Please ask for: Mrs D Johnson
Email: daun.johnson@arun.gov.uk
Telephone: 01903 737762
Our Ref: Y/98/20/PL
Your Ref:
Date: 25th September 2020

Application for Planning Permission

Development: Erection of 75 No. dwellings with associated parking, public open space & the creation of a new vehicular access. This application affects the character & appearance of the Main Road/Church Road Conservation Area & affects the setting of listed buildings.

Location: Bonhams Field Main Road Yapton BN18 0DX

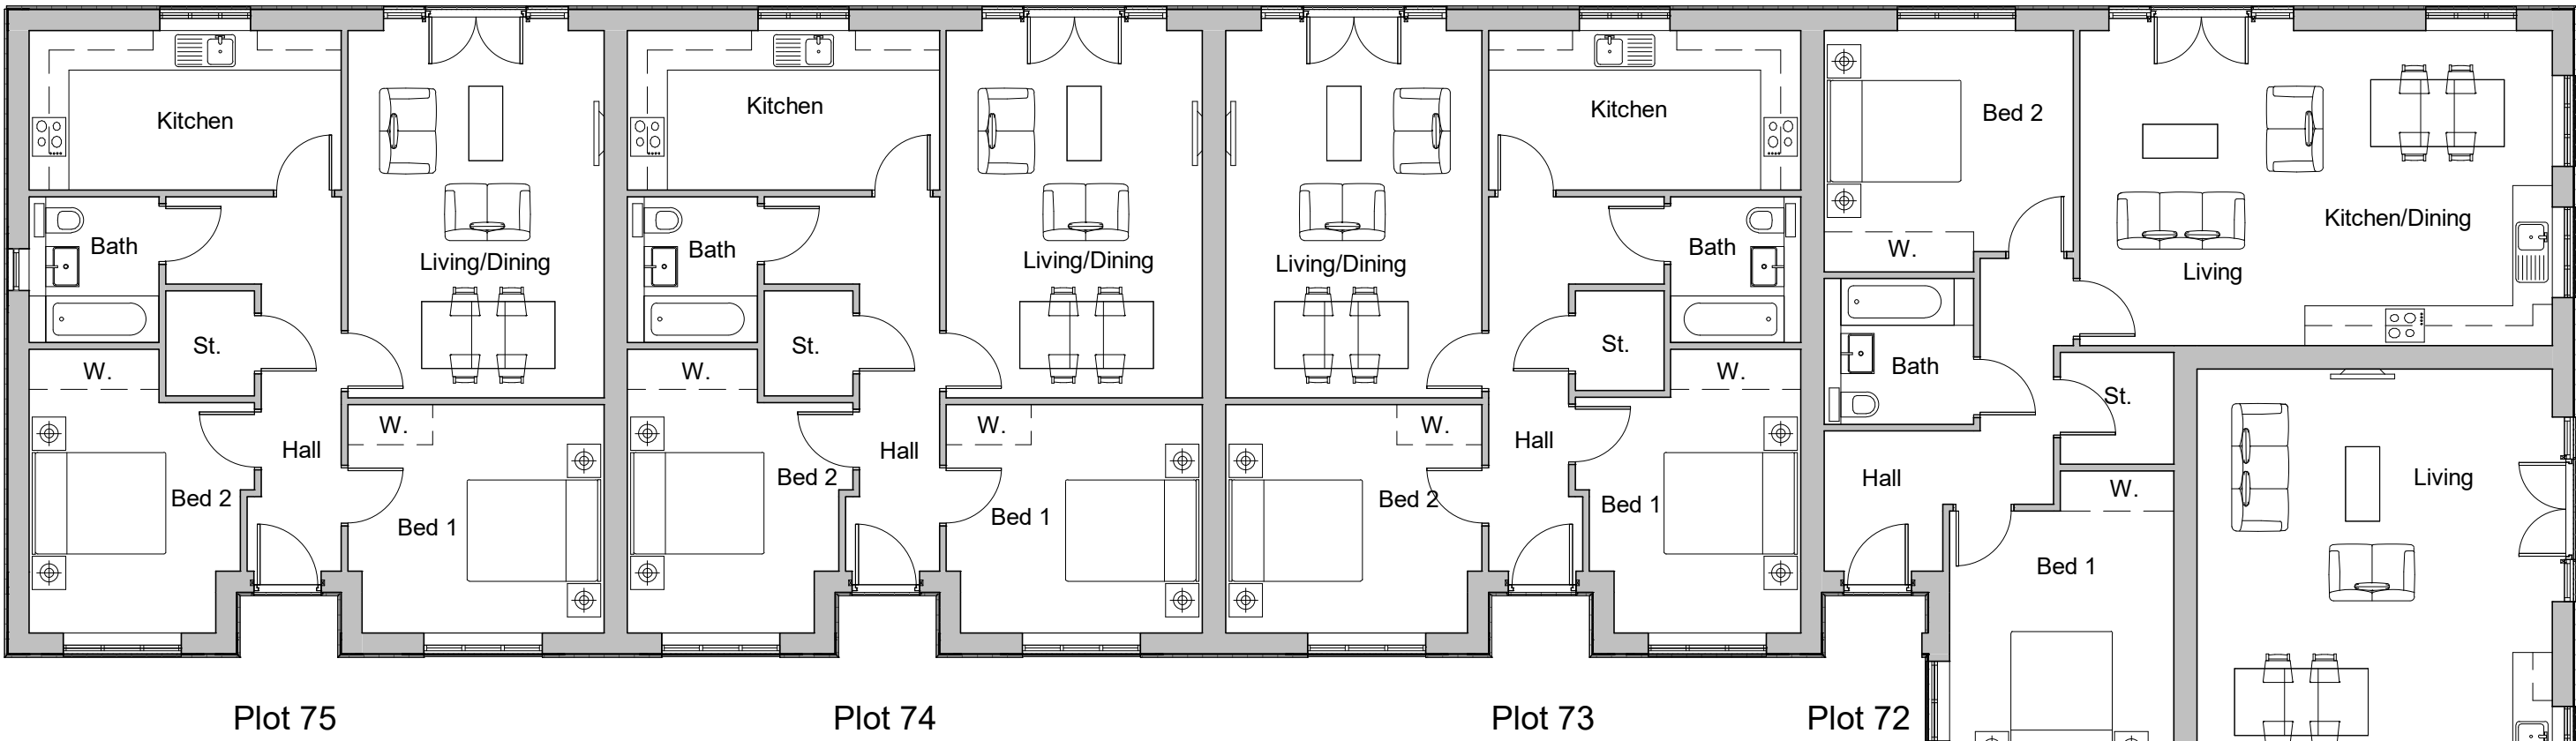
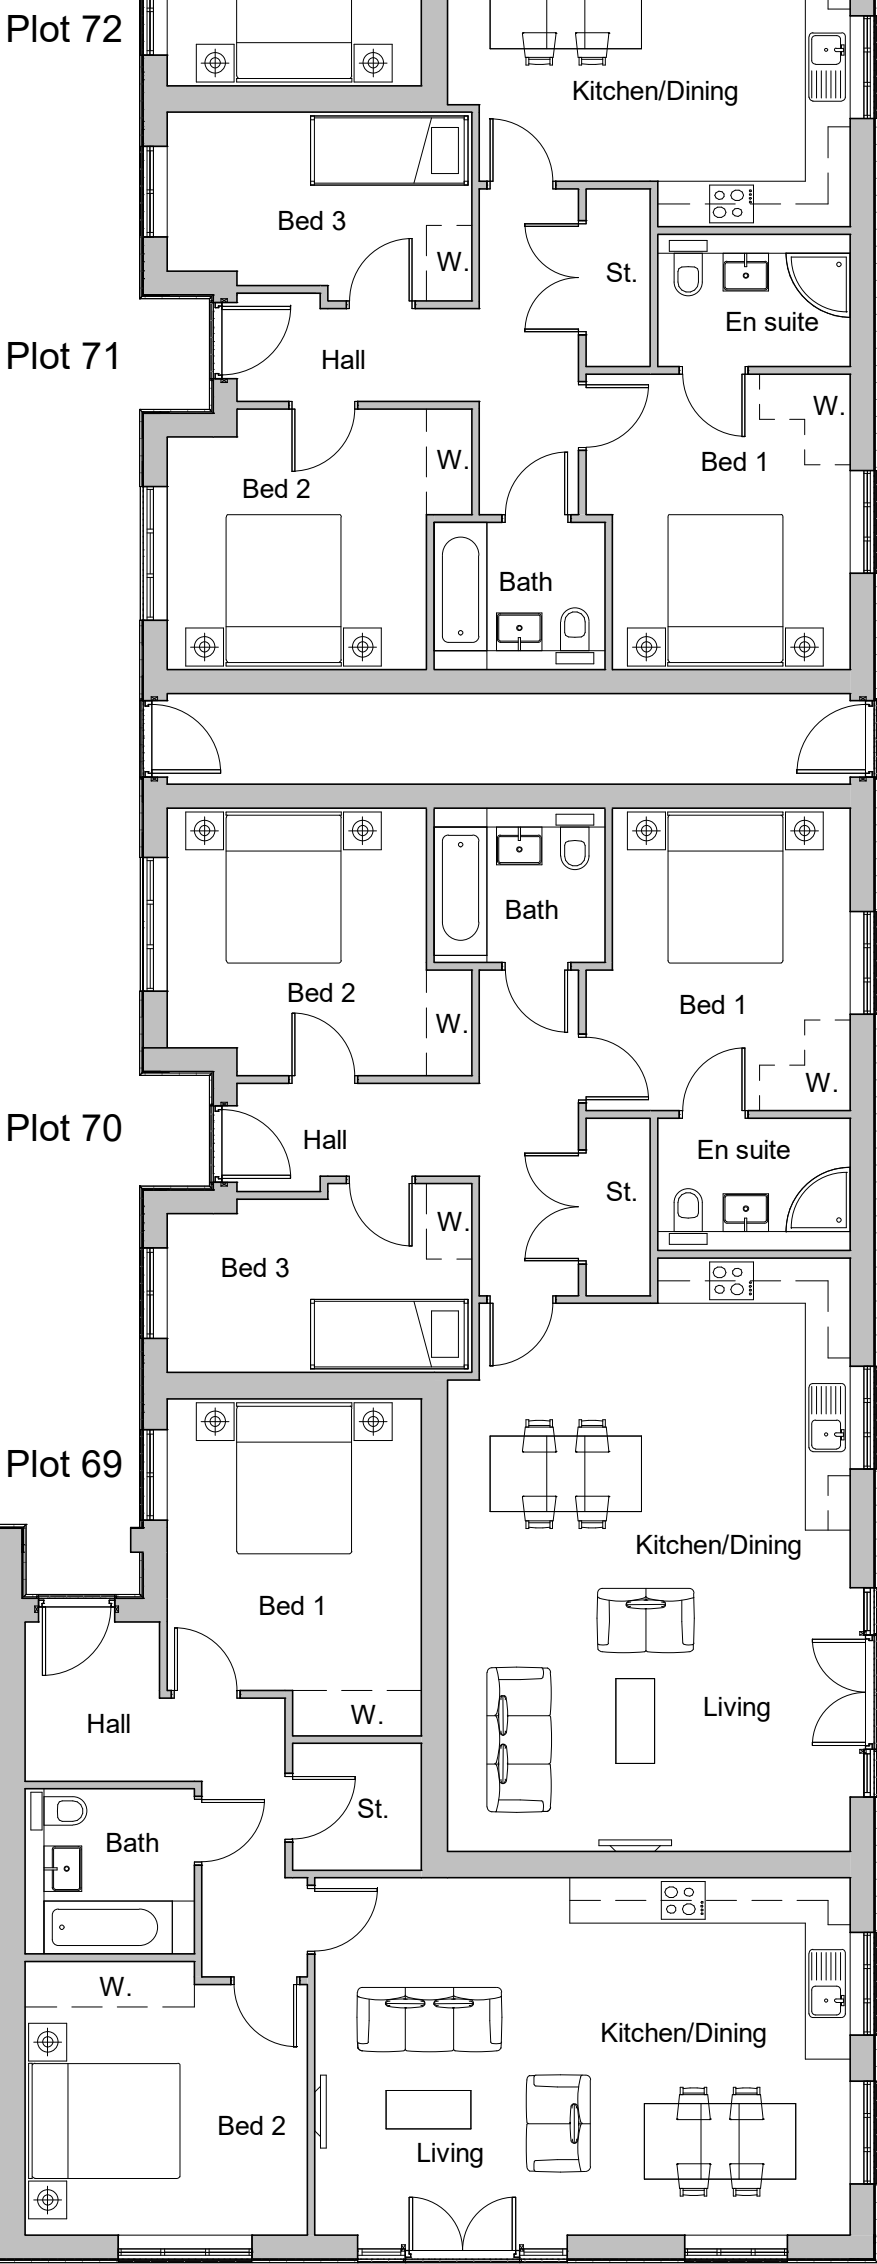
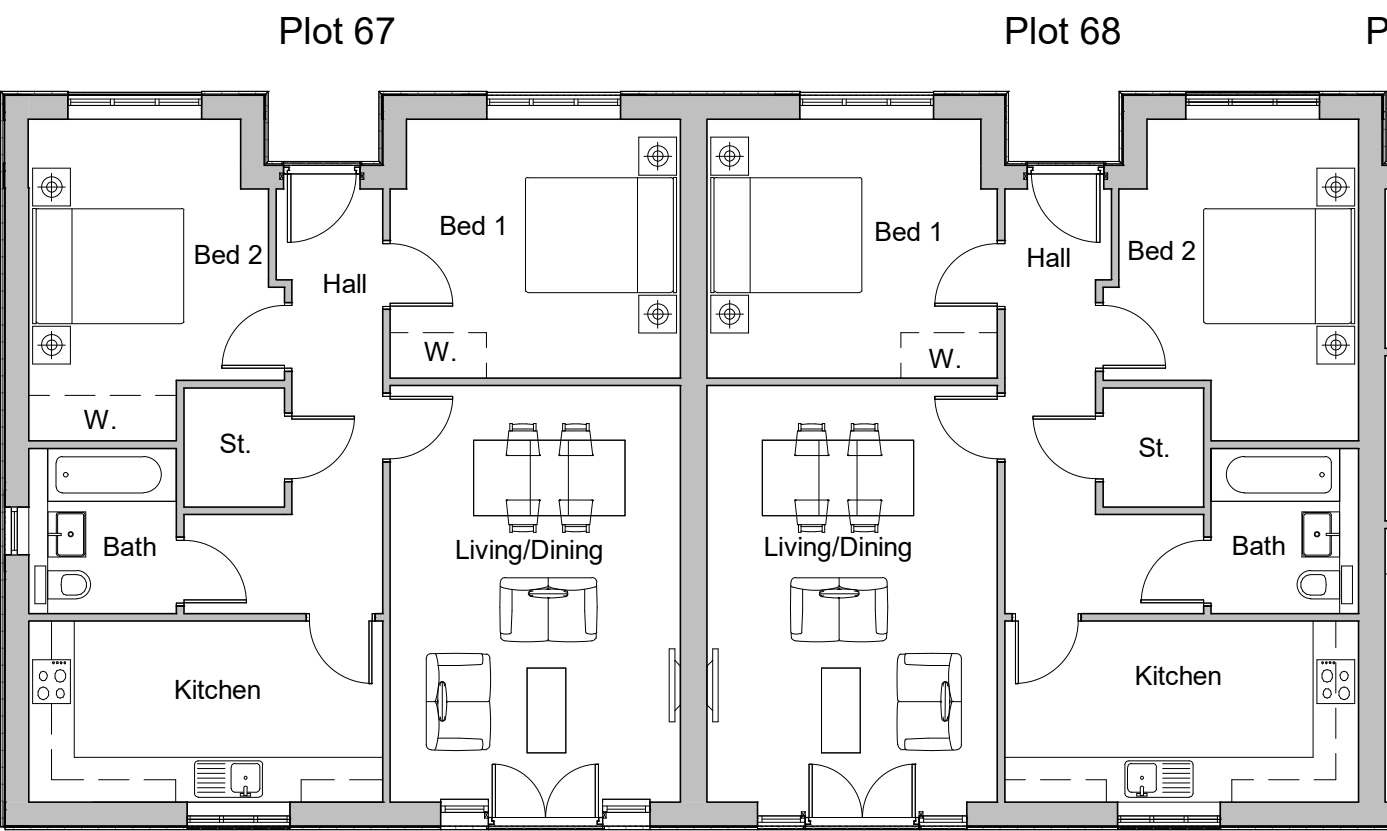
On plans P110, P124, P129 and P131, please confirm the North, south, east and west points are labelled correctly.
